WEST SUSSEX COUNTY COUNCIL CONSULTATION

TO:	Arun District Council FAO: Silvie Steiningerova
FROM:	Highways, WSCC
DATE:	20/11/2025
LOCATION:	2 Rose Cottages, Climping Street, Climping, BN17 5RH
SUBJECT:	CM/29/25/HH Part single, part two storey side and single storey rear extensions and creation of a drive, following demolition of existing extensions. This application may affect the setting of a Grade II Listed Building.
DATE OF SITE VISIT:	N/A
RECOMMENDATION:	Advice
S106 CONTRIBUTION TOTAL:	N/A

WSSC Highways response

DRAWING TITLE  
Location and Block Plan

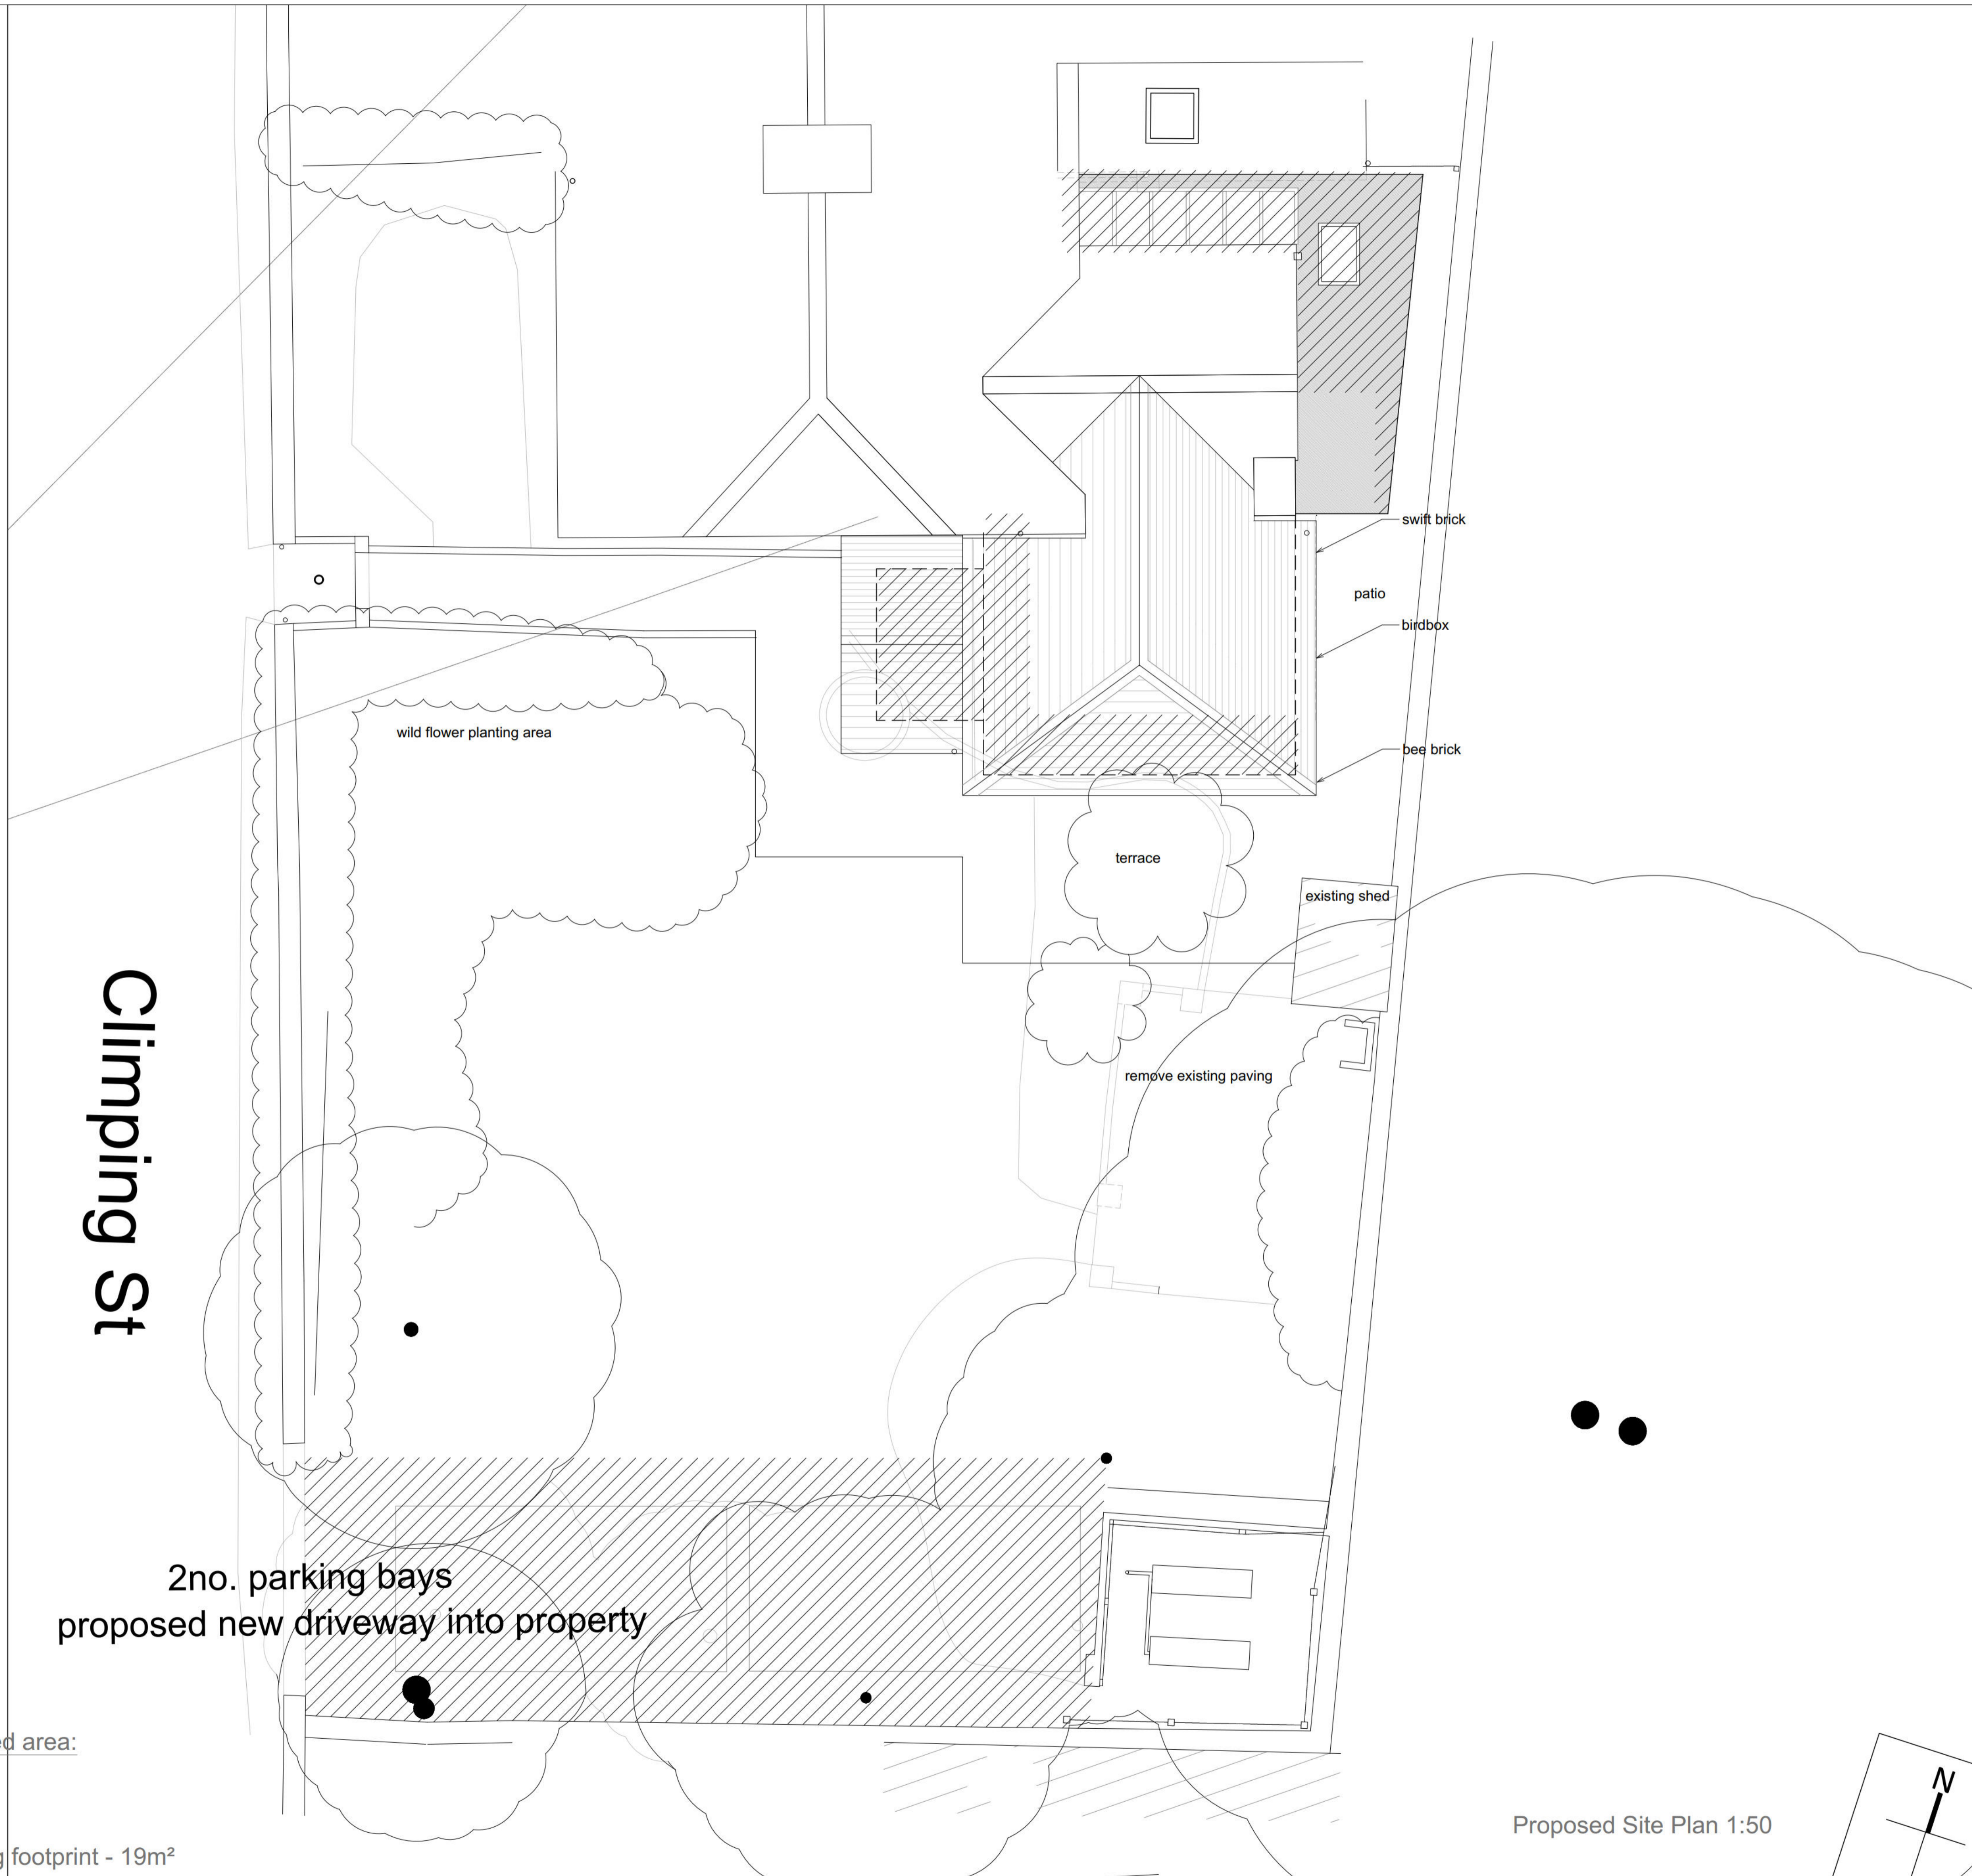
For the current submission, a new vehicular access point is proposed on Climping Street, to facilitate access to a new drive providing two off-street car parking spaces. The proposed access works will be subject to a vehicle crossover (VCO) licence obtained through the local WSCC Highway Area Office and constructed to a specification agreed with the local WSCC Highway Area Engineer.

Visibility splays of 2m x 25m have been demonstrated in accordance with Manual for Streets (MfS) parameters for a 20 mph speed restriction. The LHA request that visibility be secured by condition, to ensure suitable visibility is maintained in perpetuity.

The proposed drive appears of suitable size to accommodate two off-street car parking spaces. On-site turning does not appear achievable, so vehicles may have to exit in a reverse gear – however, this would not be anticipated to give rise to an adverse highway safety impact, owing to sufficient demonstrated vehicular visibility and that Climping Street benefits from good forward visibility in this location.

No part of the development shall be first occupied until visibility splays of 2 metres by 25 metres have been provided at the proposed site vehicular access onto Climping Street in accordance with the approved planning drawings. Once provided the splays shall thereafter be maintained and kept free of all obstructions over a height of 0.6 metre above adjoining carriageway level or as otherwise agreed.
